Diary against Annex Website Submissions for job #5132 SSI-5132, Epping to Thornleigh Third Track Project

Submission on Application SSI-5132 Northern Sydney Freight Corridor Epping to Thornleigh Third Track

I object to the gross scale and abject lack of heritage sympathy of the 'indicative design' proposed for Cheltenham station.

Figure 5.6 Cross-section and elevation - New Cheltenham Station concourse building
Note: Indicatively added to future design

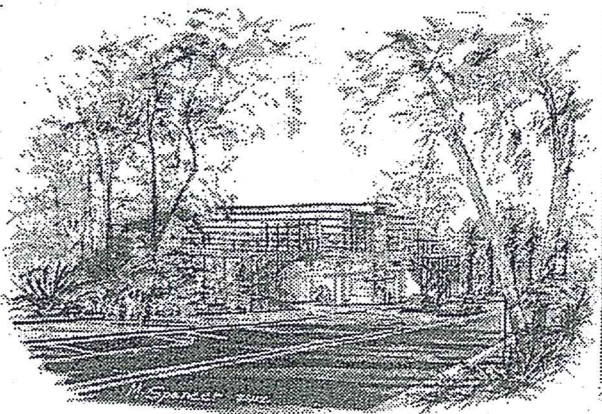
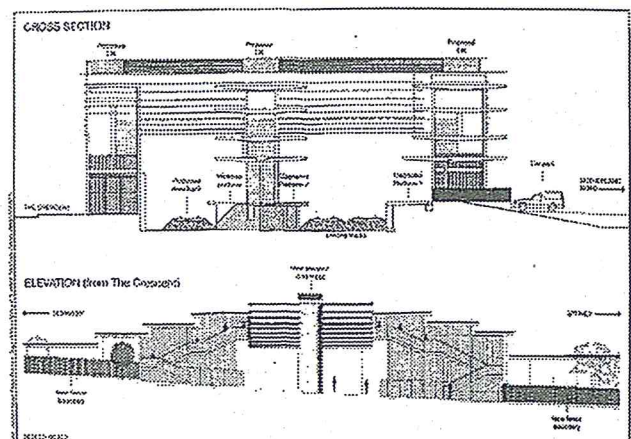
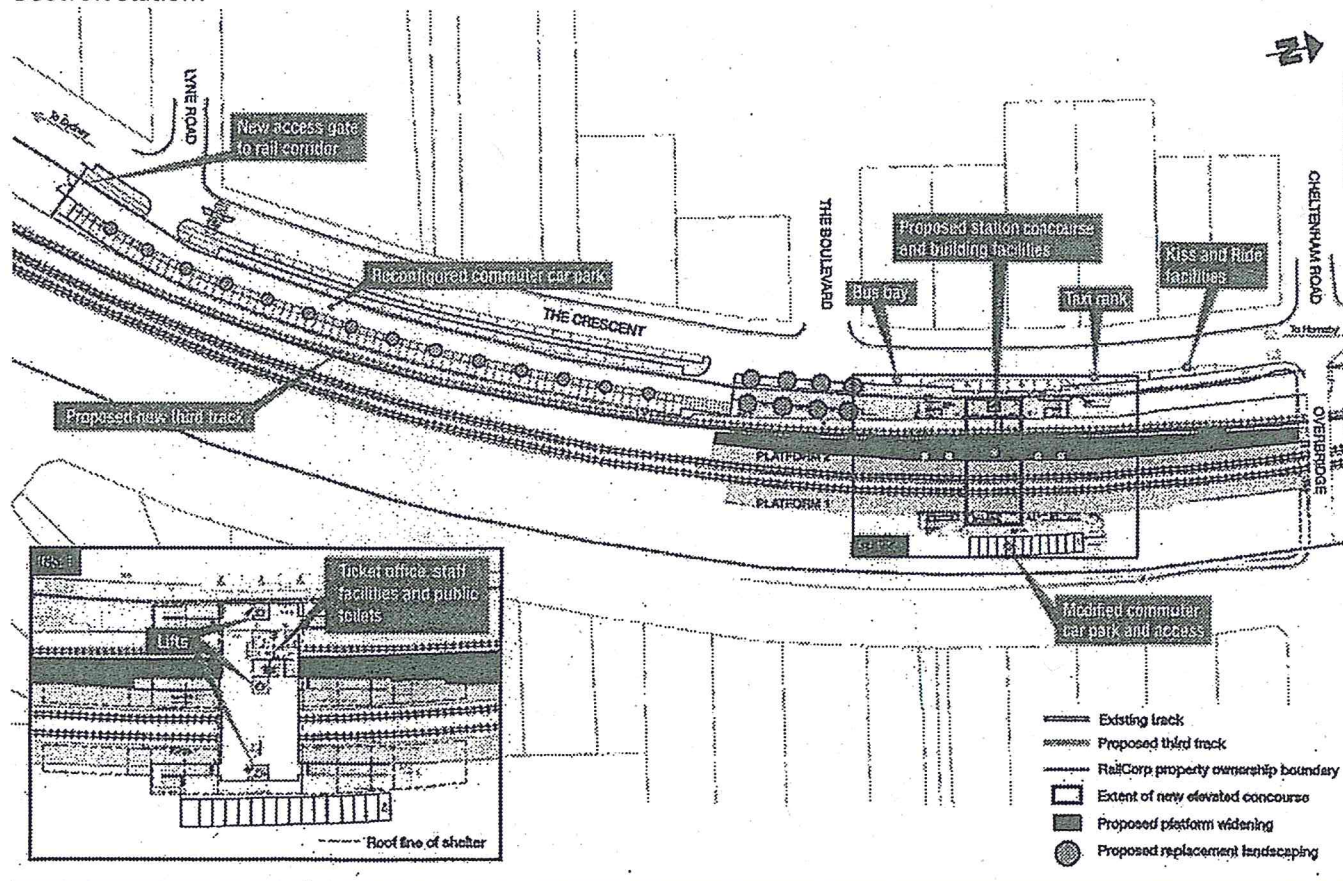
Replacement of the Cheltenham stations offers the opportunity to provide a new building that is more consistent with the area in terms of materials and general shape than the existing station. Instead, a standard design is proposed that is highly intrusive, excessively large, and totally out of character with its surrounds. The scale of the building proposed is unnecessary for what is presently just a local station and which will continue be. The station is presently only staffed by one person on weekday mornings. It is otherwise unattended.

The new station must be built using materials and shapes that respect the visual heritage. This does not mean slavishly copying historic styles but it does mean that the building should not stand out from its neighbours, as would the indicative design. The Beecroft Cheltenham Civic Trust has expertise in this area and must be extensively consulted.

The proposed station could be considerably improved by altering the design to a smaller concourse closer to the Cheltenham Road bridge, such that it can be accessed from the bridge. This would remove the need for at least one of the lifts, reduce the staircases required and screen the mass of the station by placing it partially in the cutting.
